**Ann Machado - Permit #2013-02269 - 126 Veranda Street - new duplex**

**From:** Ann Machado  
**To:** timothy@ohearninsurance.com  
**Date:** 10/11/2013 3:20 PM  
**Subject:** Permit #2013-02269 - 126 Veranda Street - new duplex  
**CC:** Philip DiPierro; Shukria Wiar

I have done my initial zoning review and at this point I cannot sign off for zoning.

A2

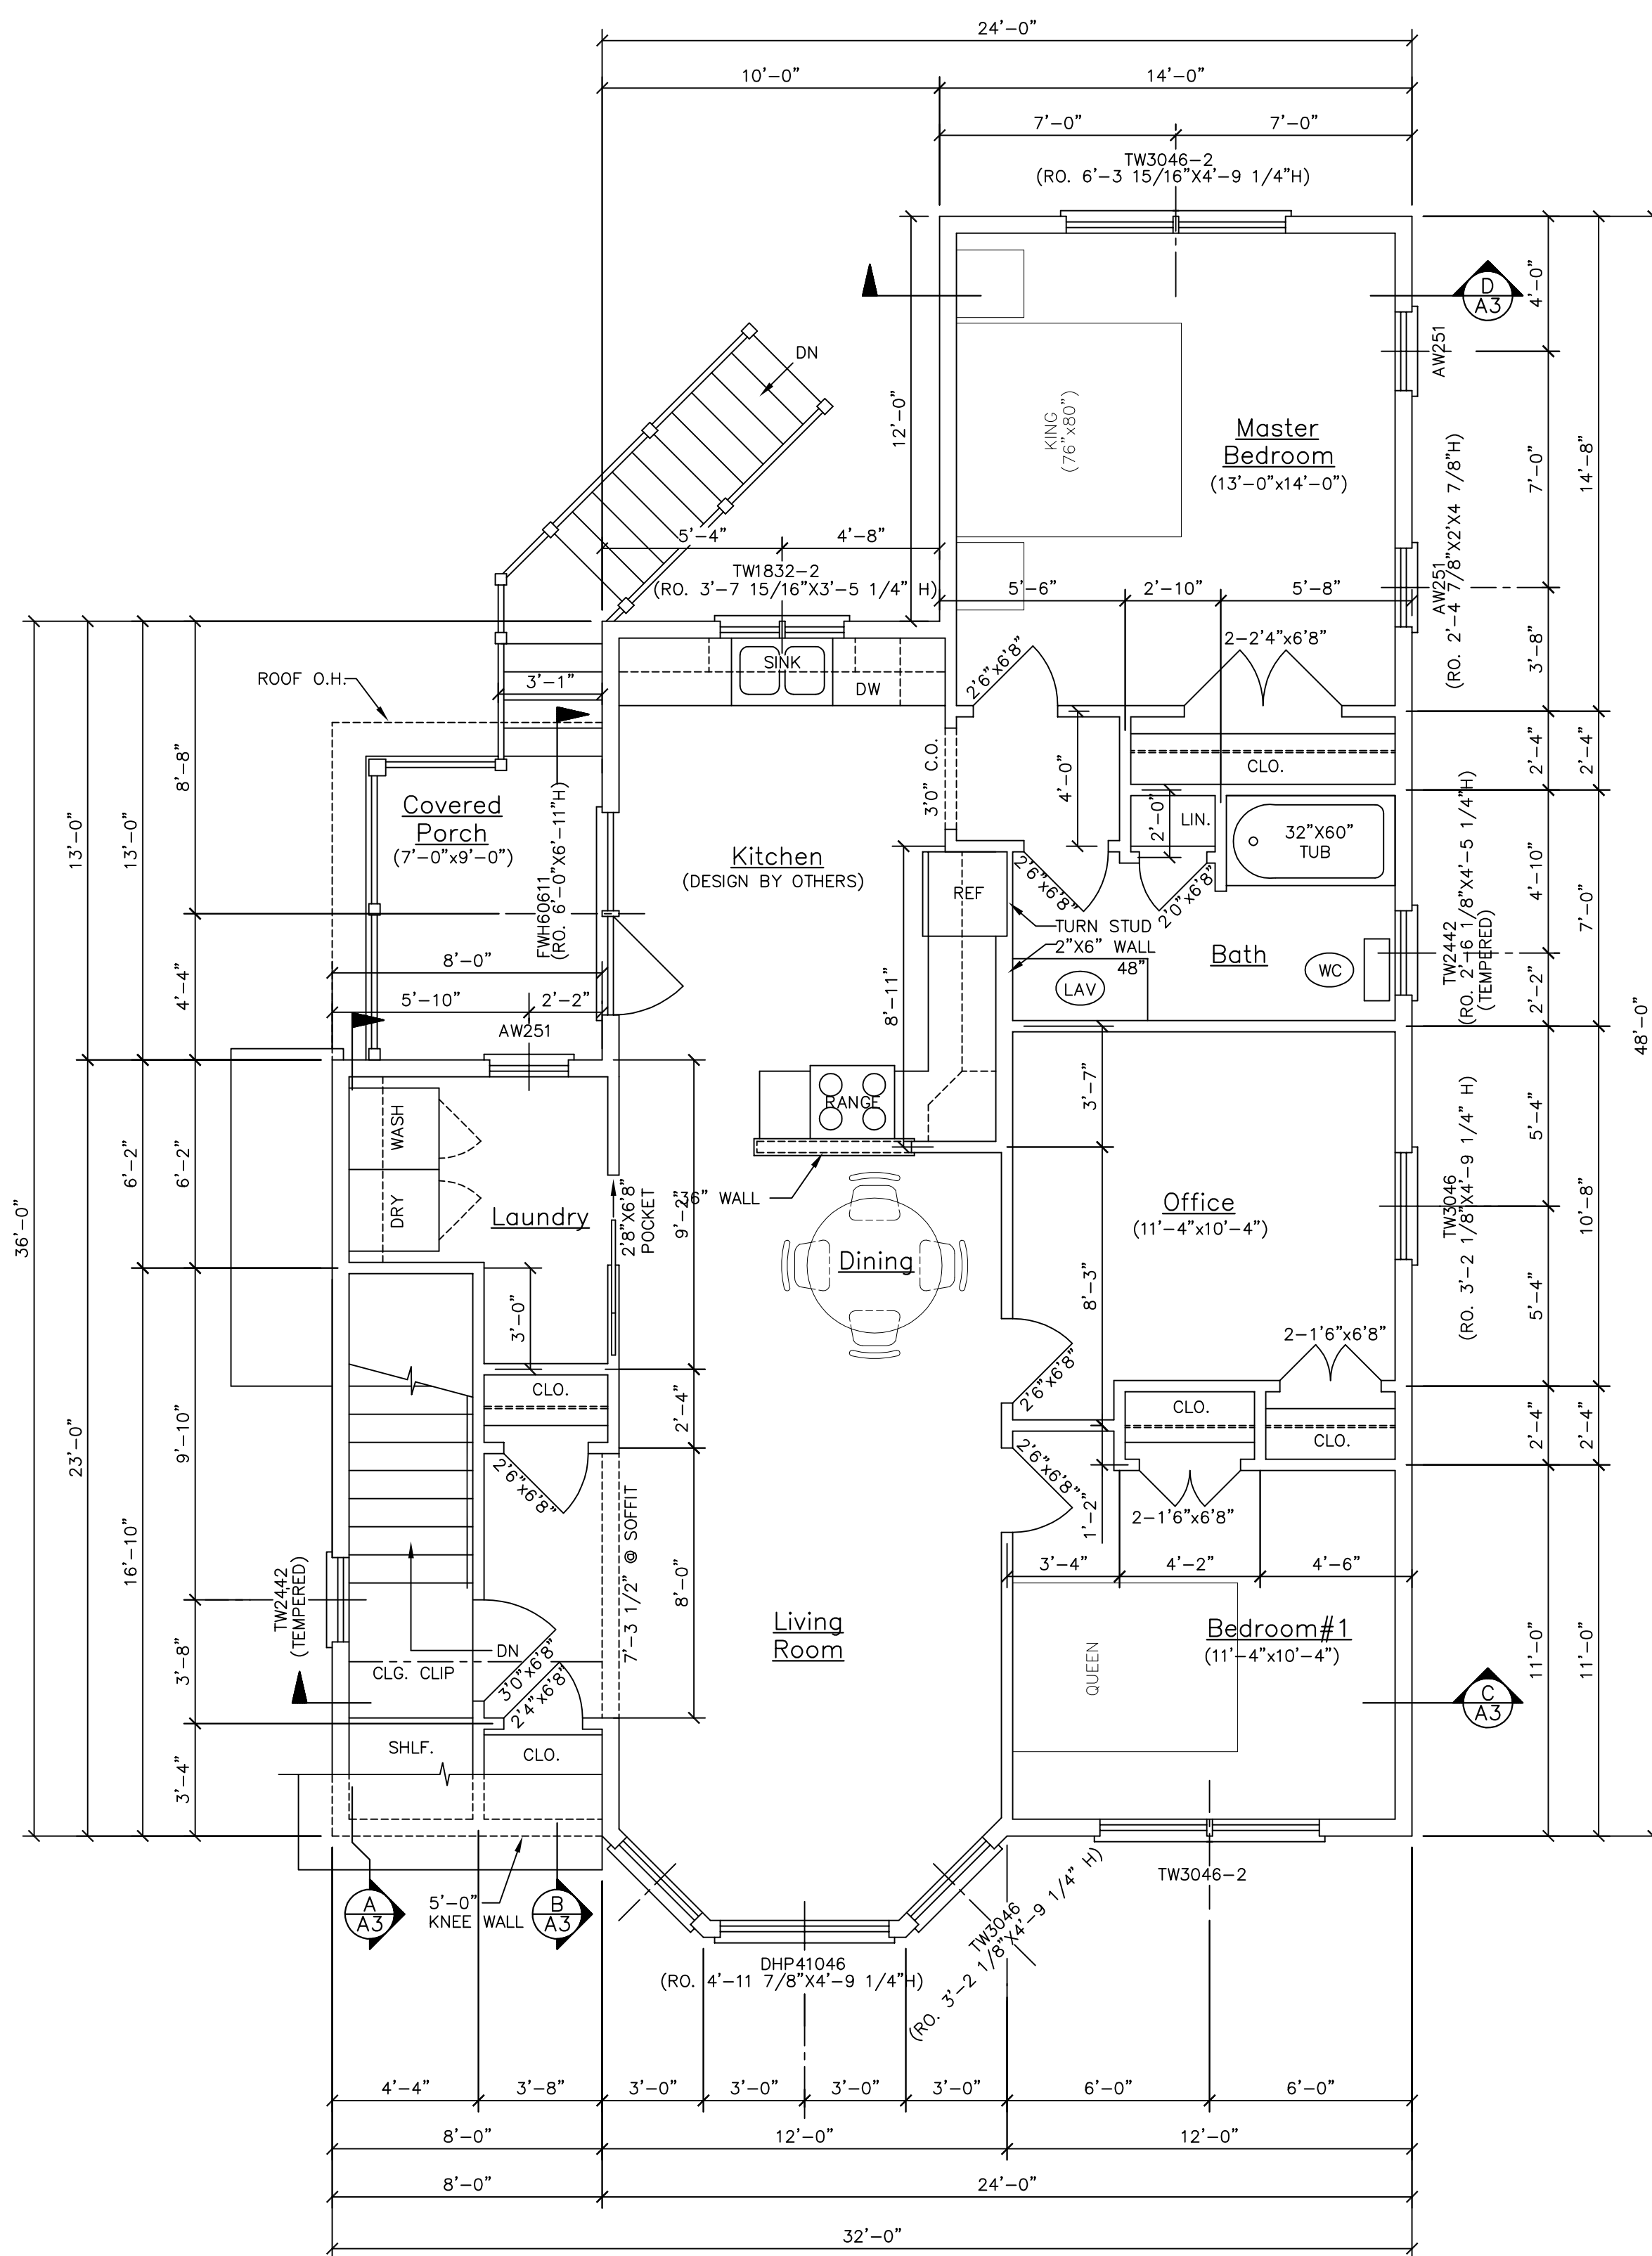
As far as zoning is concerned, the main issue is that the proposed structure does not meet the lot width requirement for the R-5 zone. Section 14-120(a)(6) gives the minimum lot width as sixty (60) feet for a duplex. Section 14-47 defines lot width as "the distance parallel to the front of the building measured between side lot lines through the part of the principal building where the lot is narrower". The lot width at the rear of the building scales at around 47' across which is well under the minimum 60' width required.
